EL PASO COUNTY GRADING AND EROSION CONTROL PLAN CHECKLIST

Add text: PPR-21-019

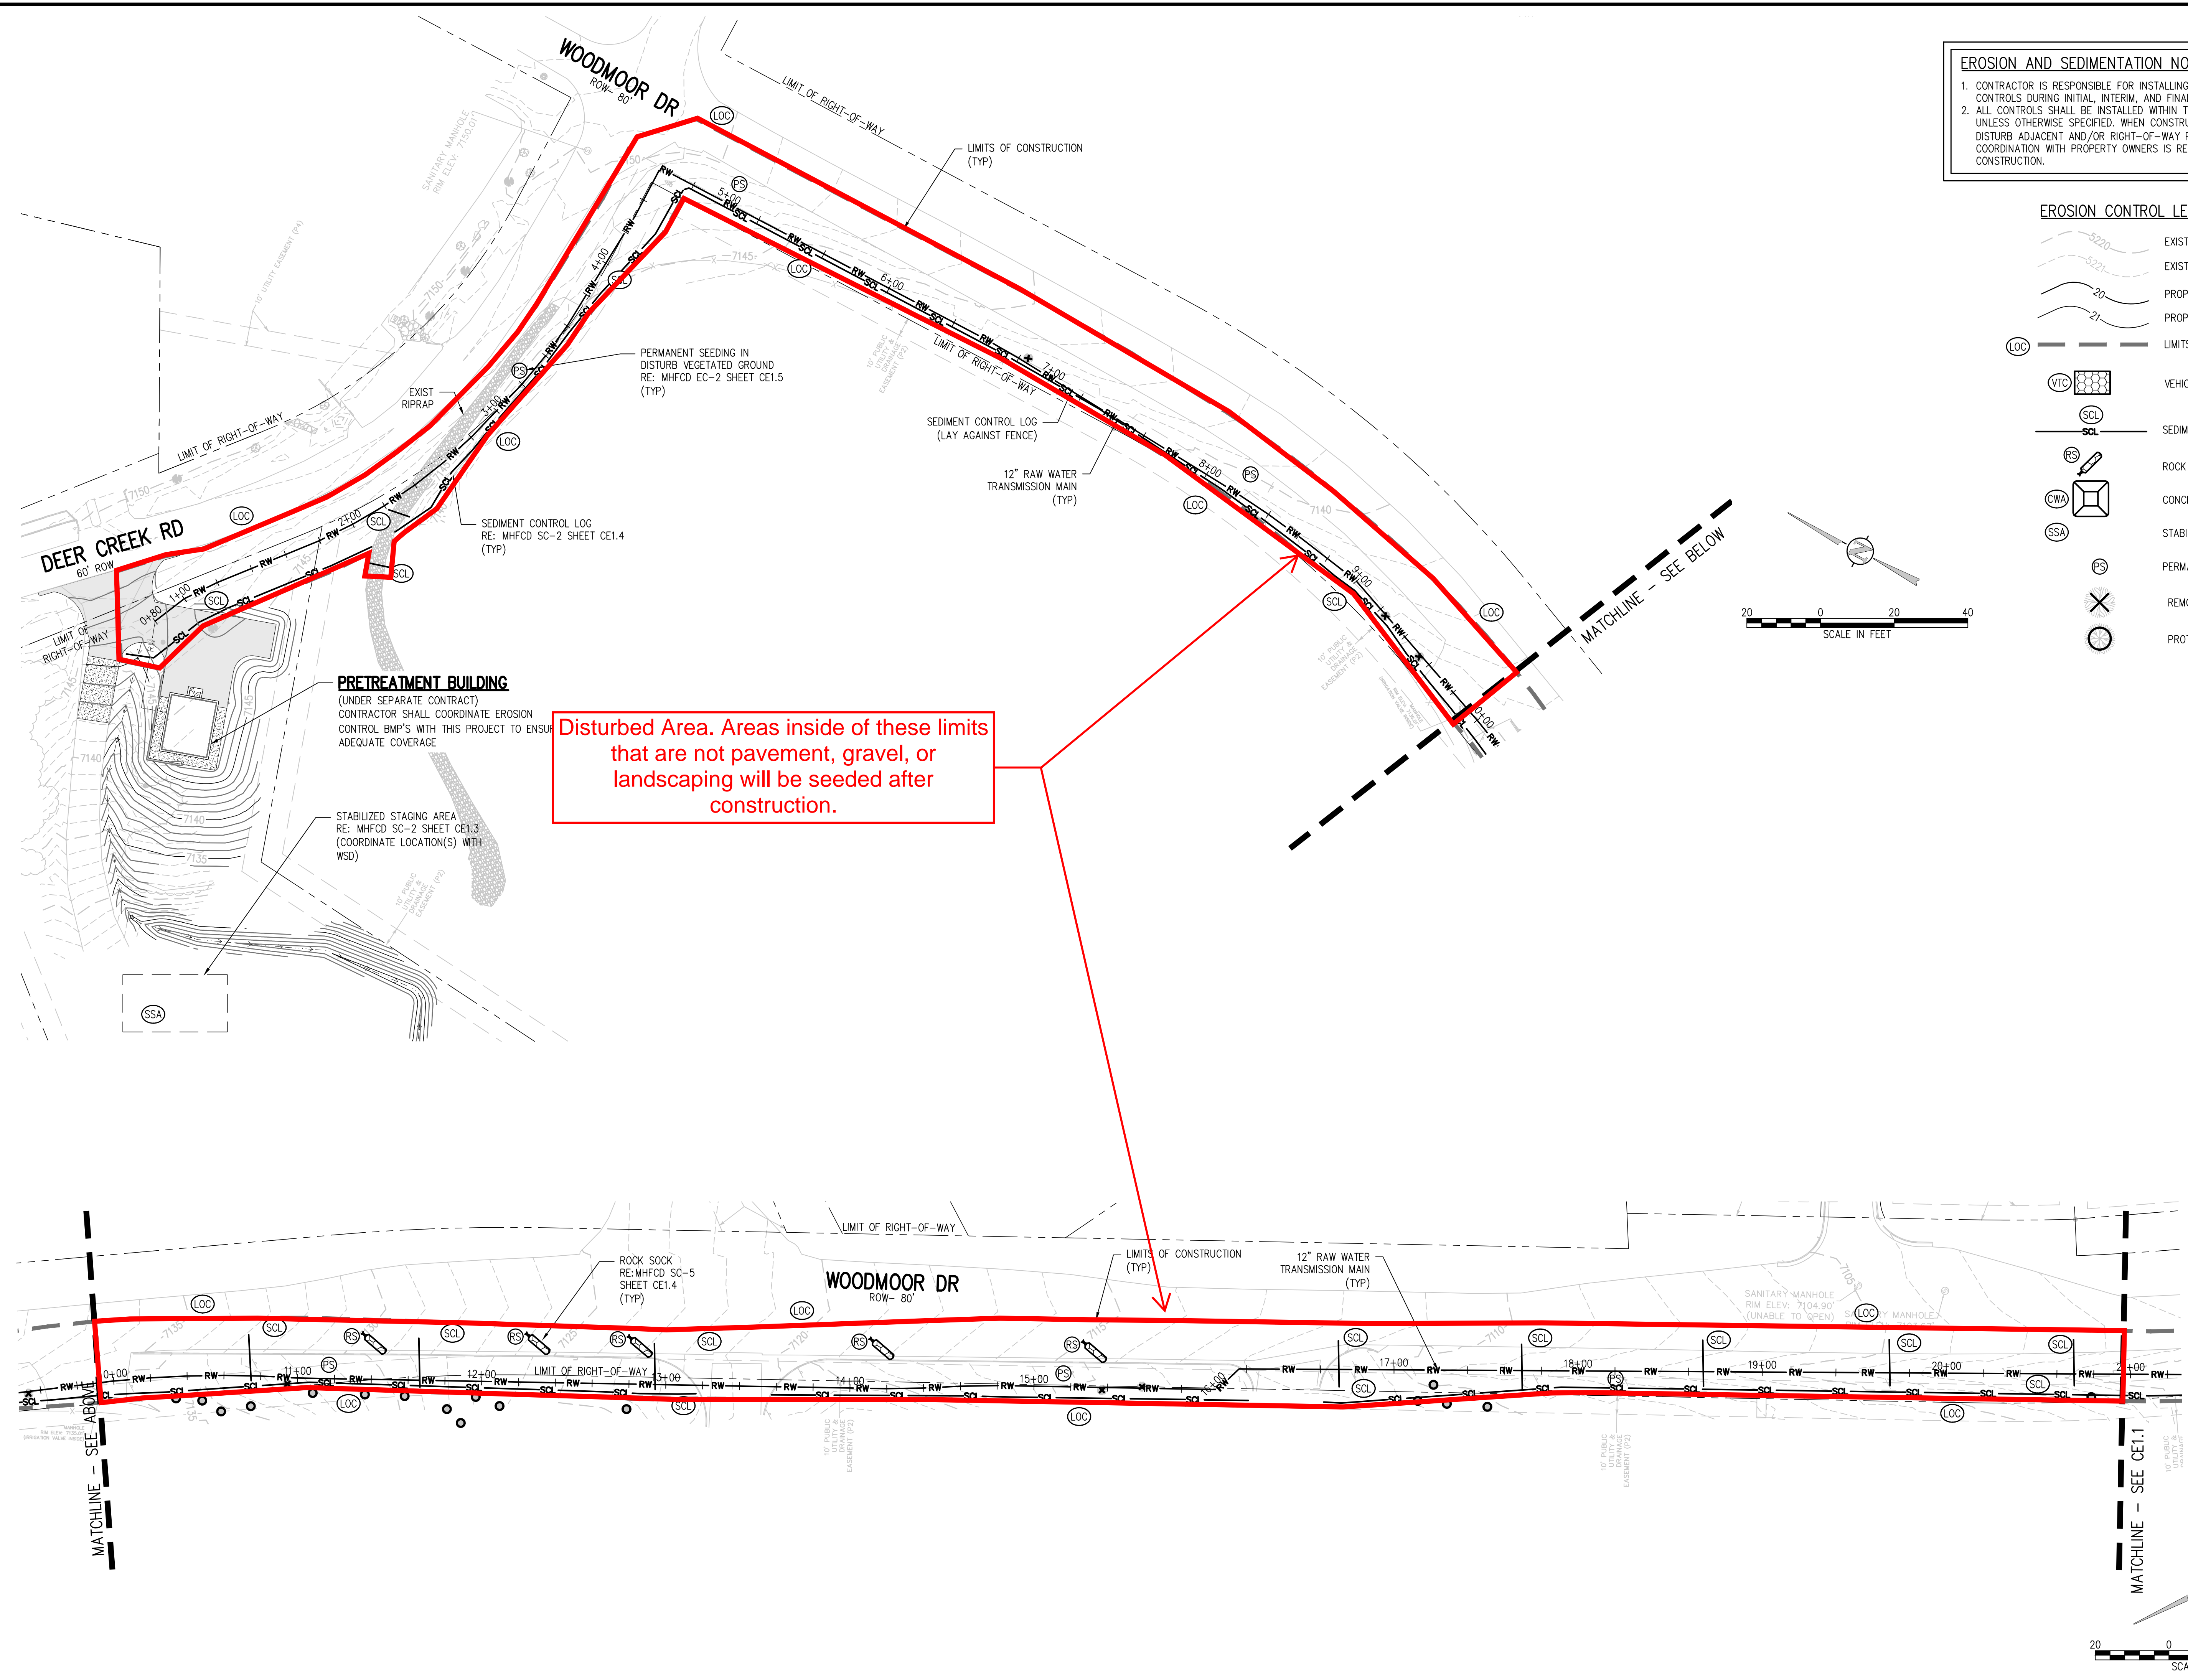
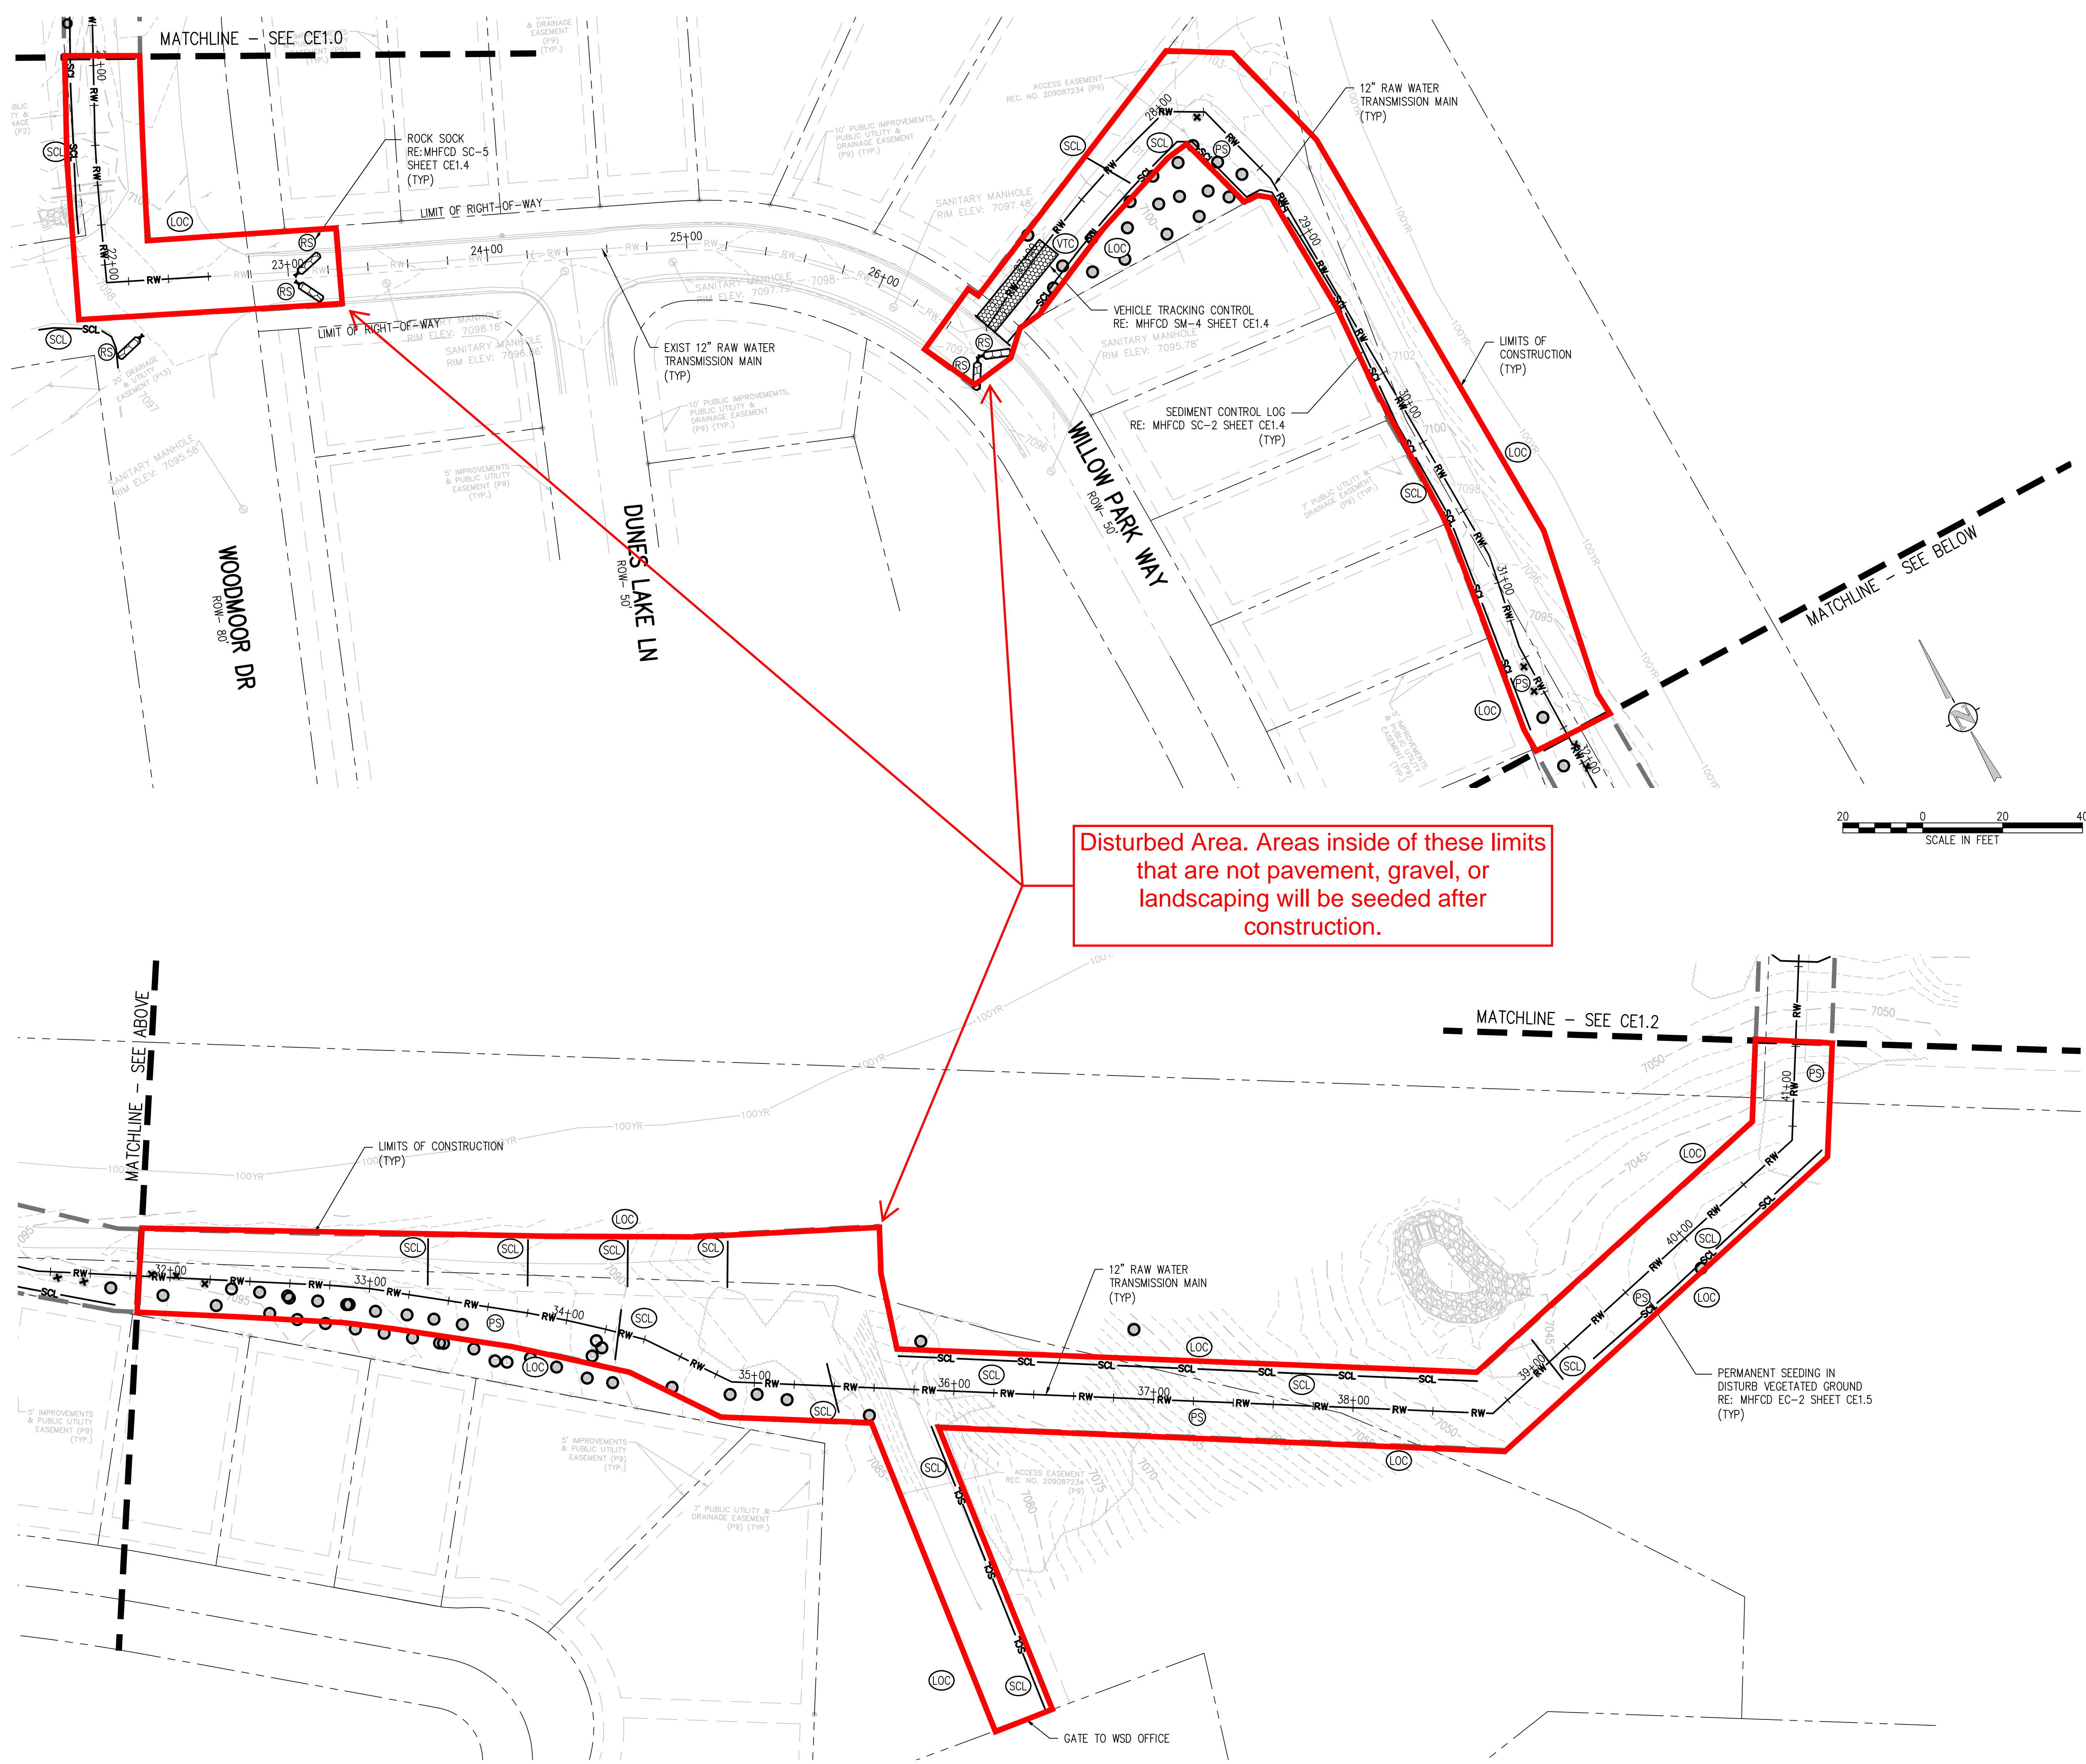
l	Existing and proposed contours 2 feet or less (except for hillside)		Y
m	Limits of disturbance delineating all anticipated areas of soil disturbance		N
n	Identify and protect areas outside of the construction site boundary with existing fencing, construction fencing or other methods as appropriate		Y
o	Off-site grading clearly shown and called out		Y
p	Areas of cut and fill identified		N
q	Conclusions from soils/geotechnical report and geologic hazards report incorporated in grading design (slopes, embankments, materials, mitigation, etc.)		Y
r	Proposed slopes steeper than 3:1 with top and toe of slope delineated. Erosion control blanketing or other protective covering required		Y
s	Stormwater flow direction arrows		N
t	Location of any dedicated asphalt / concrete batch plants		N/A
u	Areas used for staging, storage of building materials, soils (stockpiles) or wastes. The use of construction office trailers requires PCD permitting		Y
